Ref. Number **P/70/14PL** 64 Harbour Road
Pagham Planning Application

Dear Mr Roberts,
As Chair of Pagham Beach Residents and Pagham Parish Council Planning
I wish to formally object to this planning application.
The Parish Council also formally objected in October.

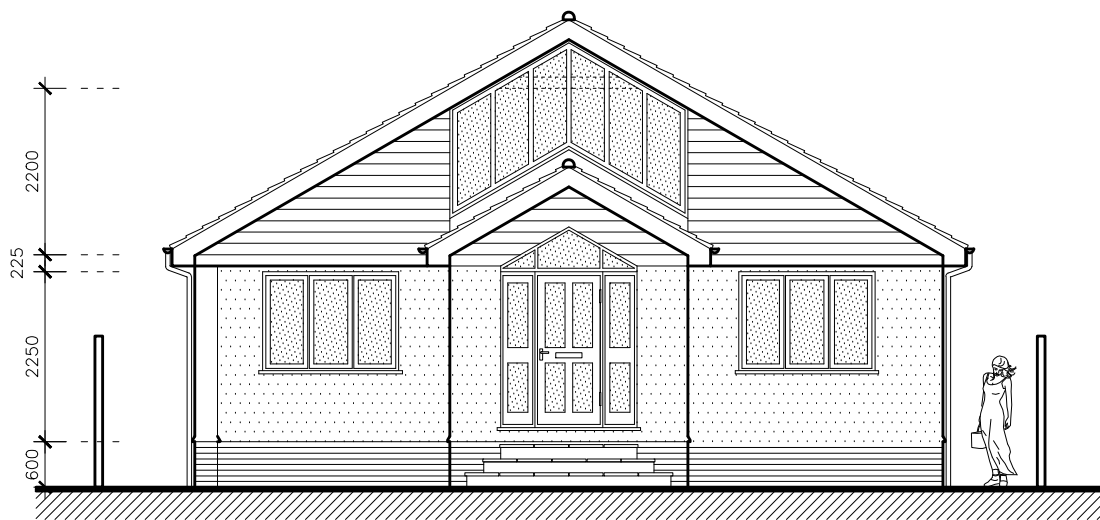
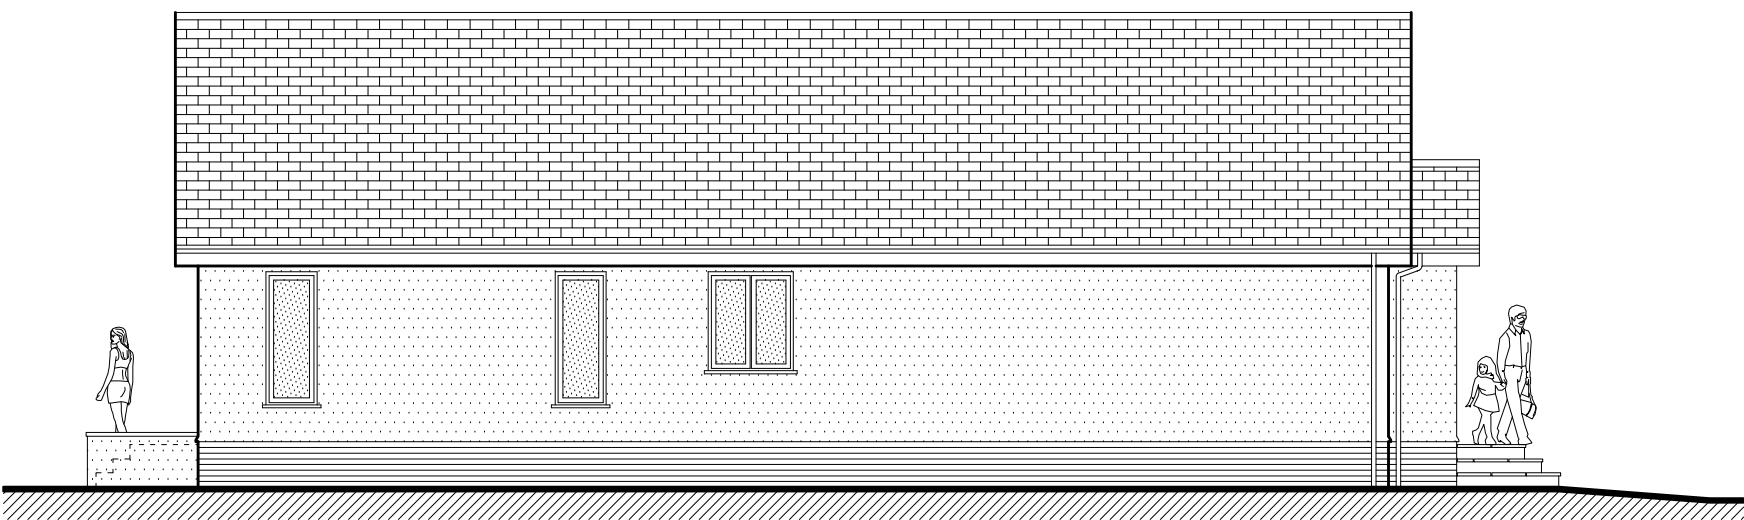
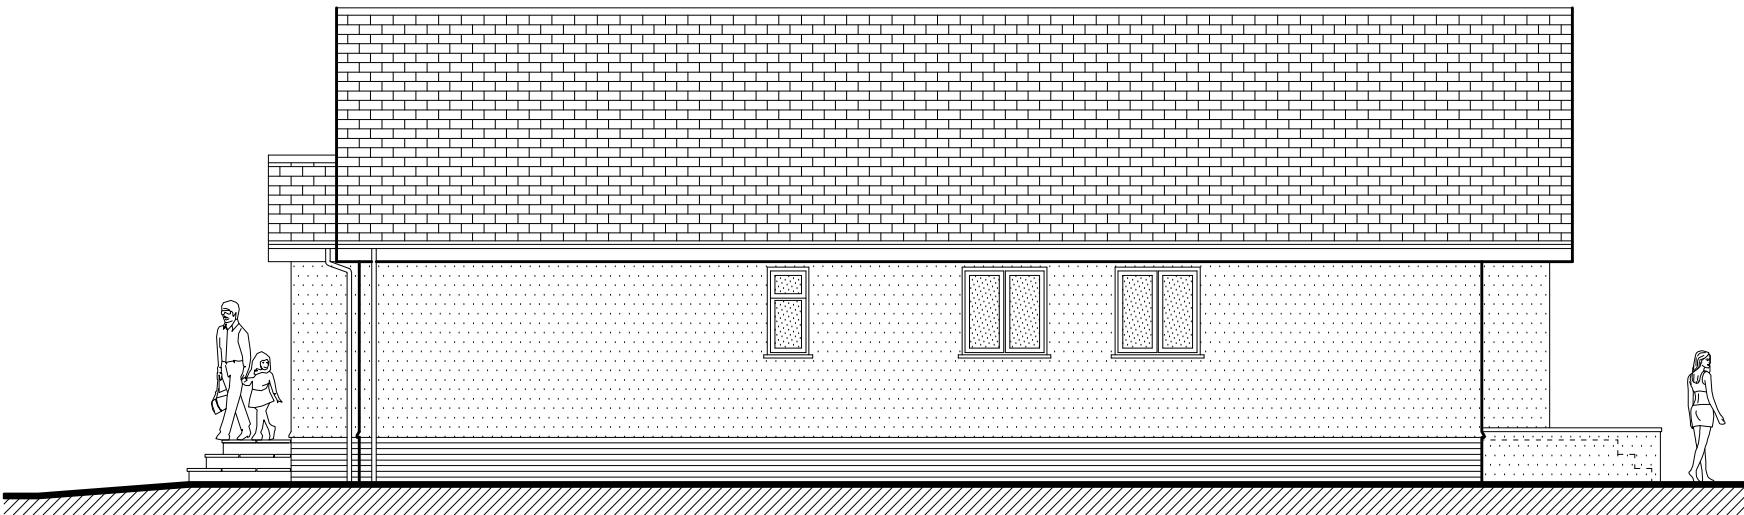
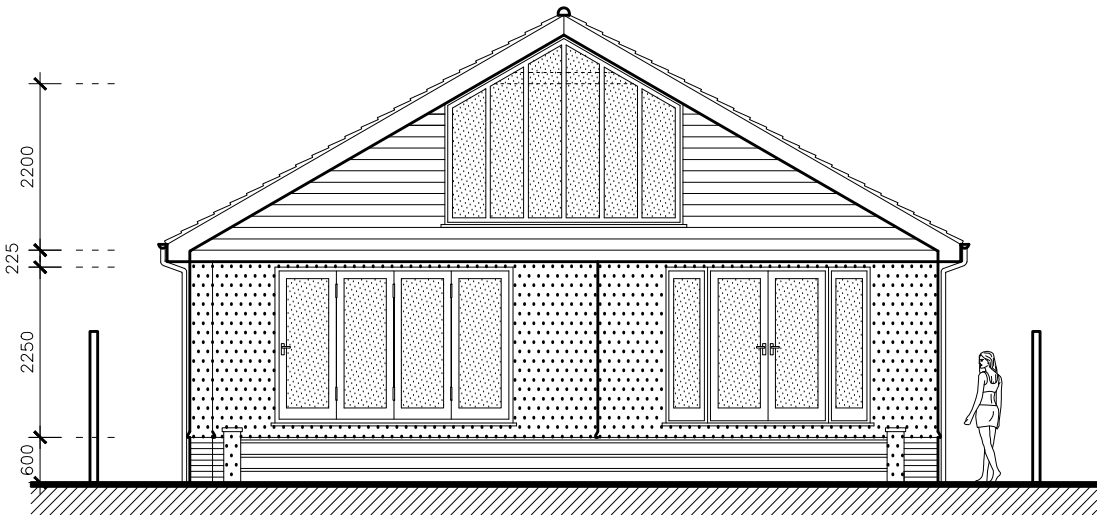
- 1 The development is too large for the site.
- 2 There is a second floor proposed contrary to our Pagham Parish village design statement and the Beach Estate of an Area of Special Character. Dwellings should be single story and not out of keeping with neighbouring properties.
- 3 The planning notice was placed on the wrong property and therefore was invalid.

TITLE:  
PROPOSED FIRST FLOOR  
PLAN

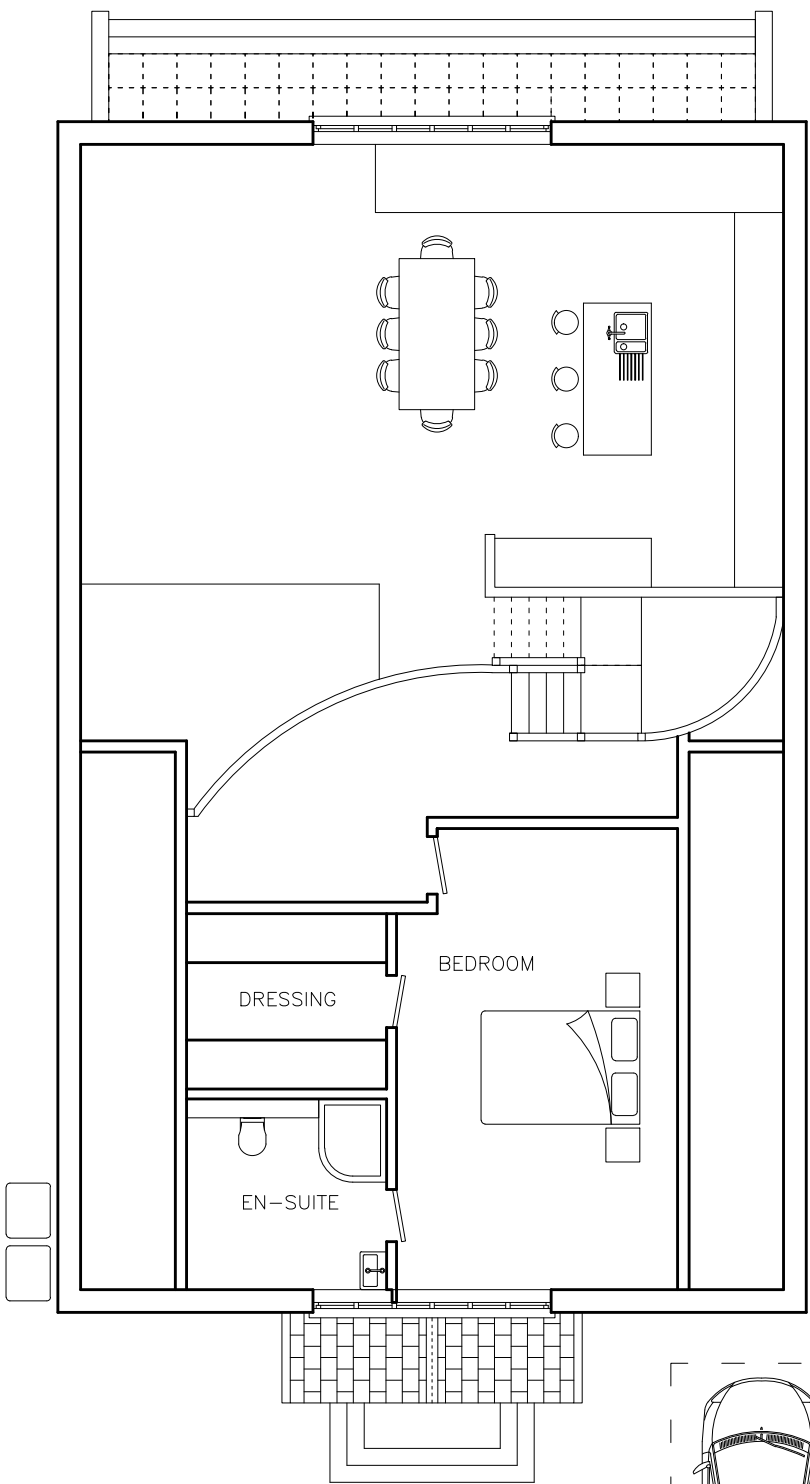
It has always been ADC policy to refuse 2 story dwellings and roof (Velux type) lights. Many people have been asked to remove their roof lights and have been refused second stories. They will naturally feel aggrieved by your inconsistencies.
